Application for Planning Permission for Works or Extension to a Dwelling

Development: Extension and alterations to form a rear facing balcony and sliding doors (part retrospective).
Location: 1 Elmer Court Elmer Middleton-On-Sea PO22 6JT

BAR/101

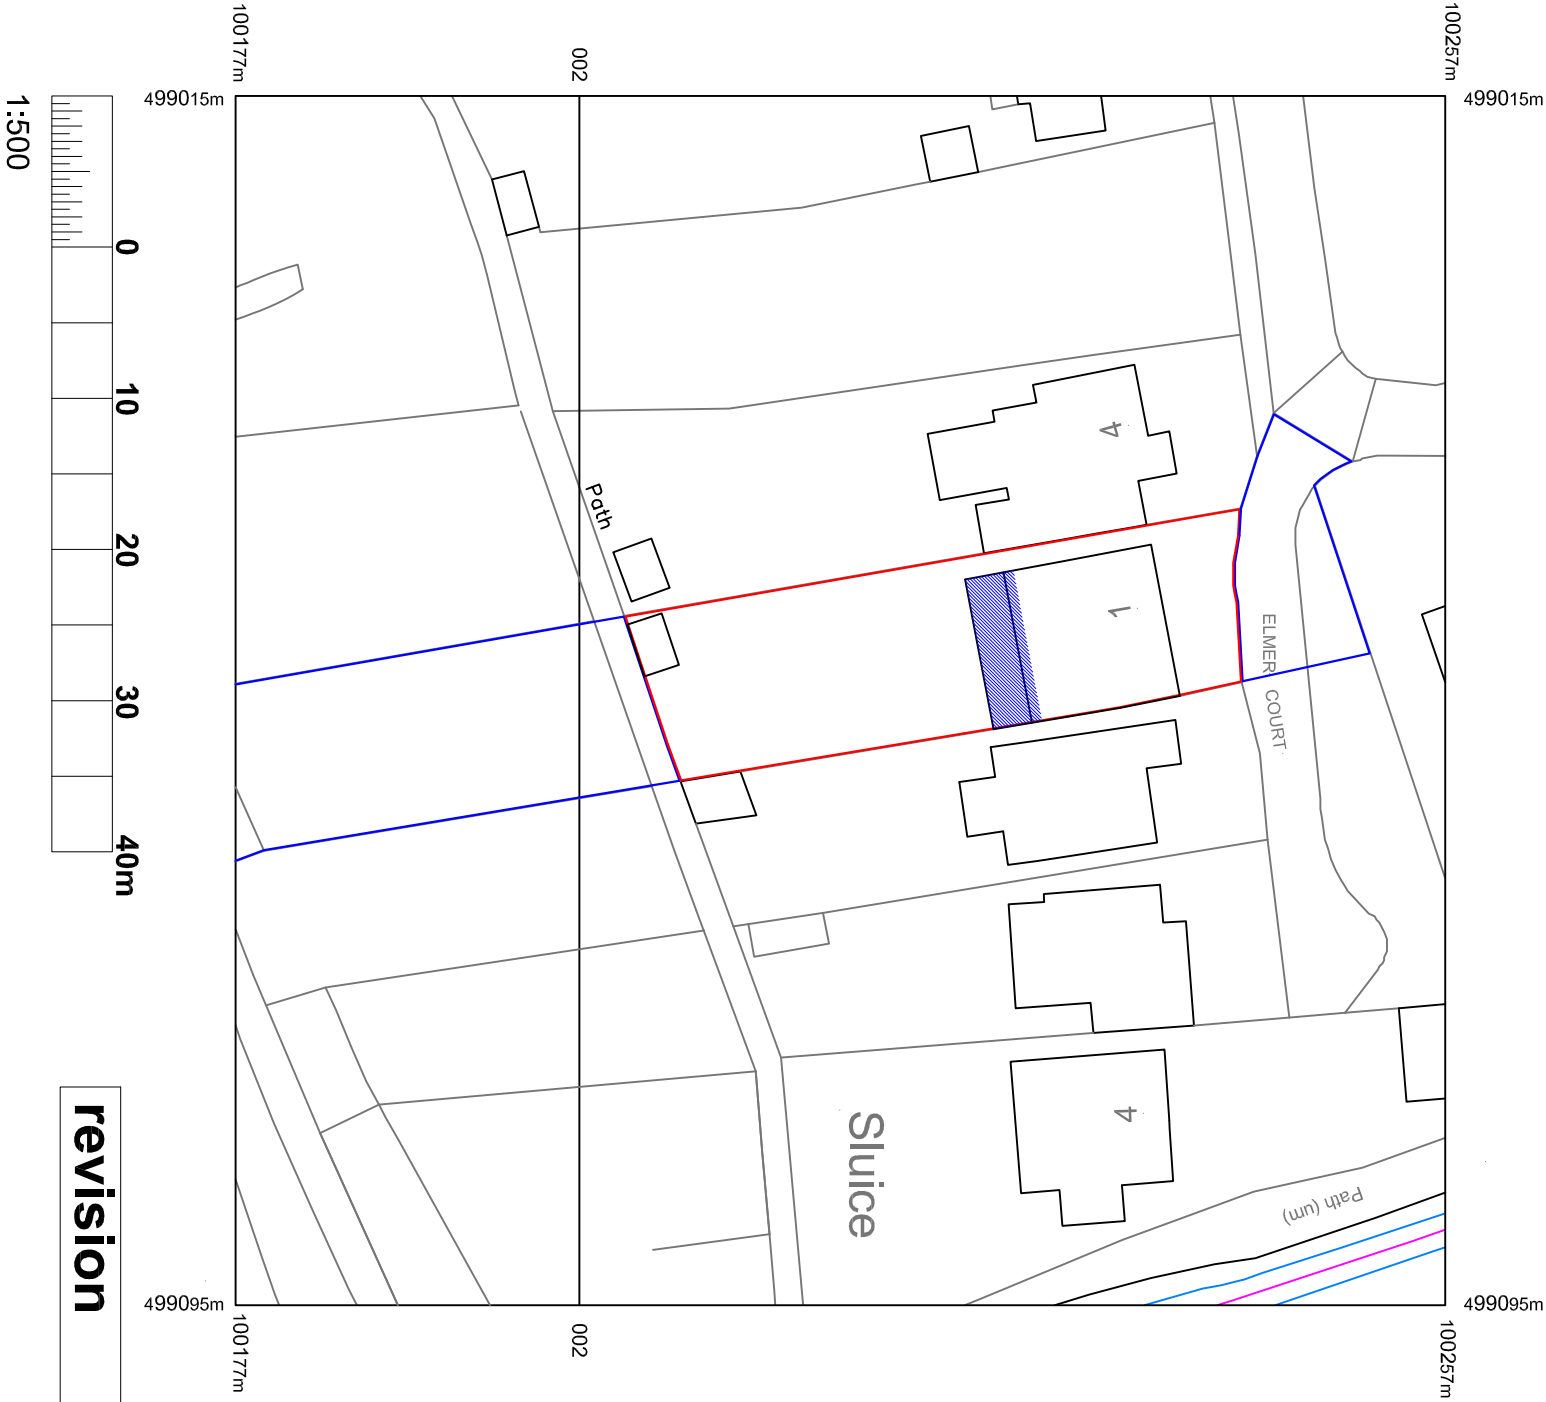
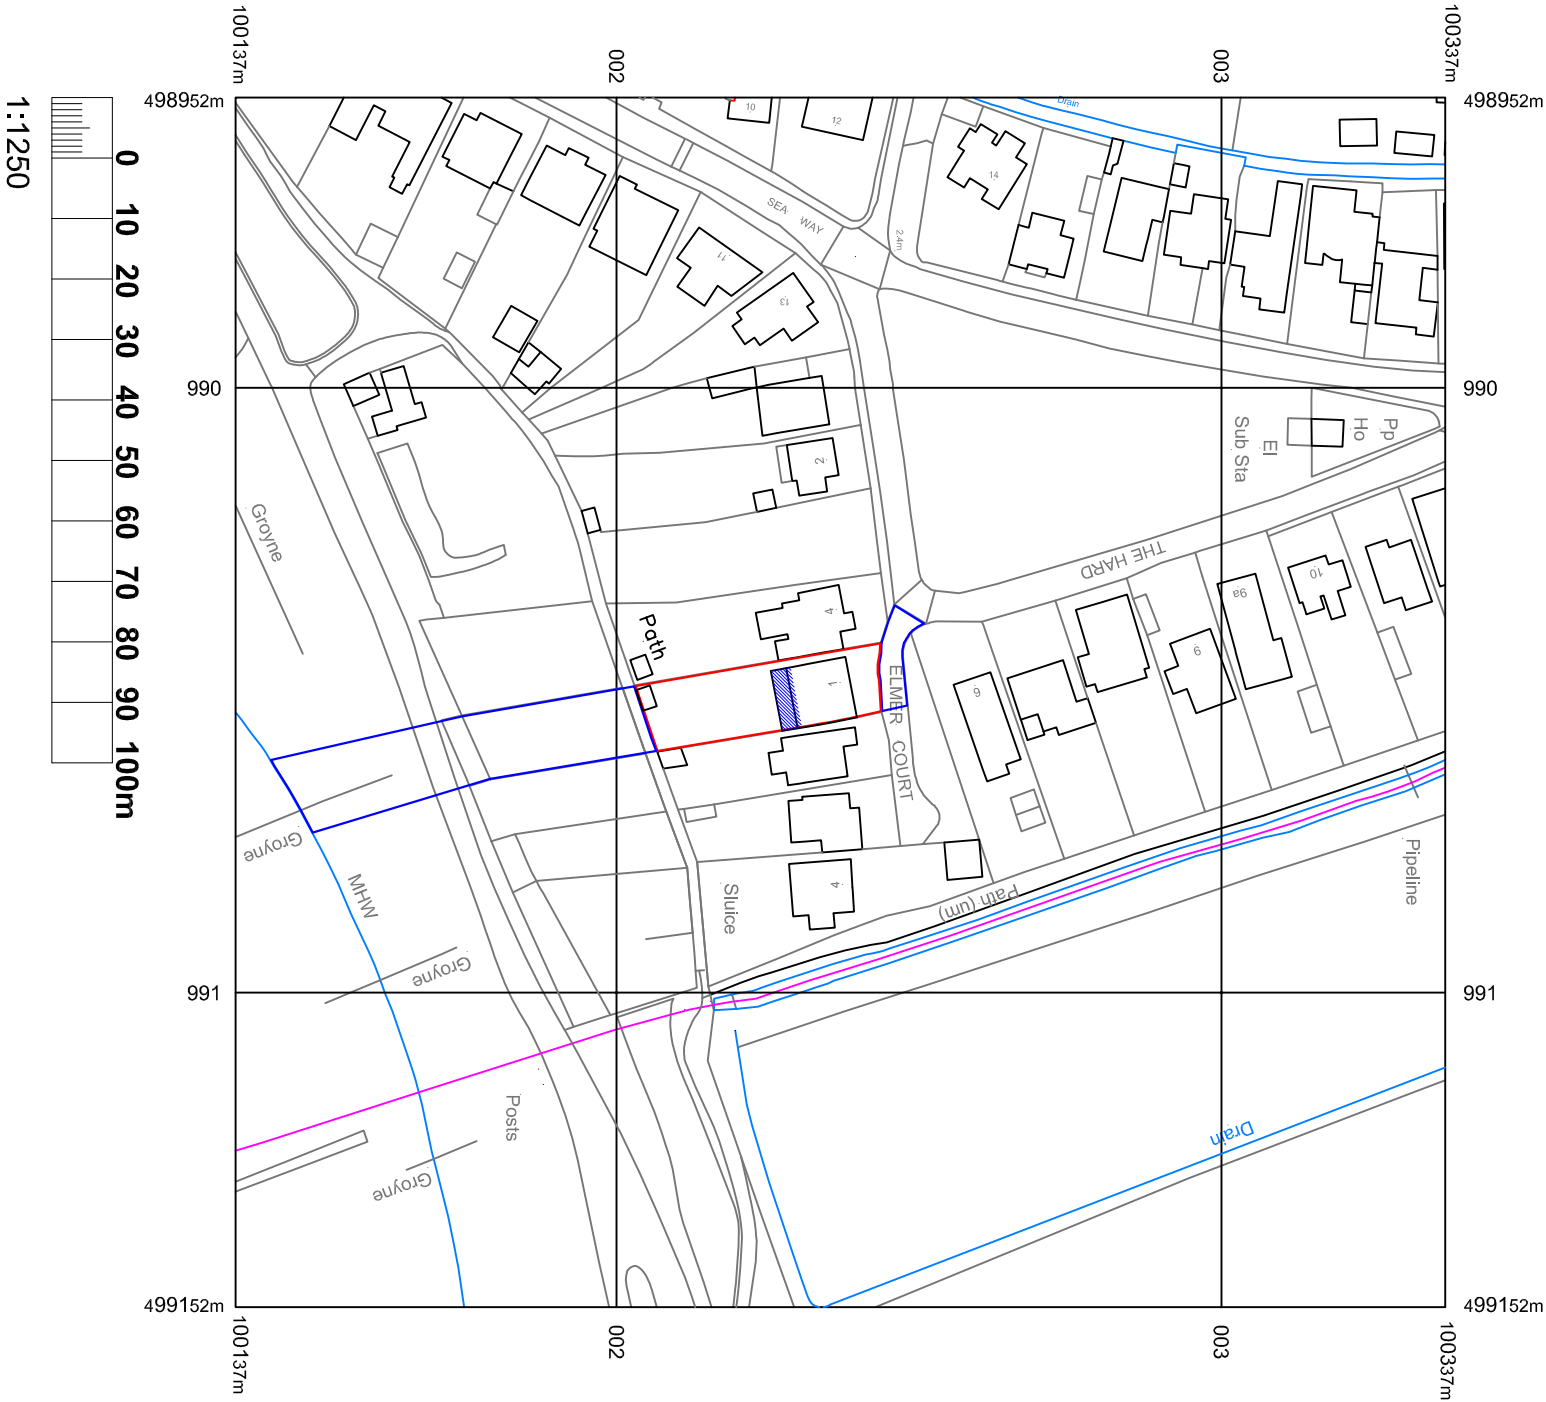
****Please note that the most recent revision does not show the below requested amendment****

Site Plan - Please add the dimensions from the proposed balcony extension to each site boundary edge.
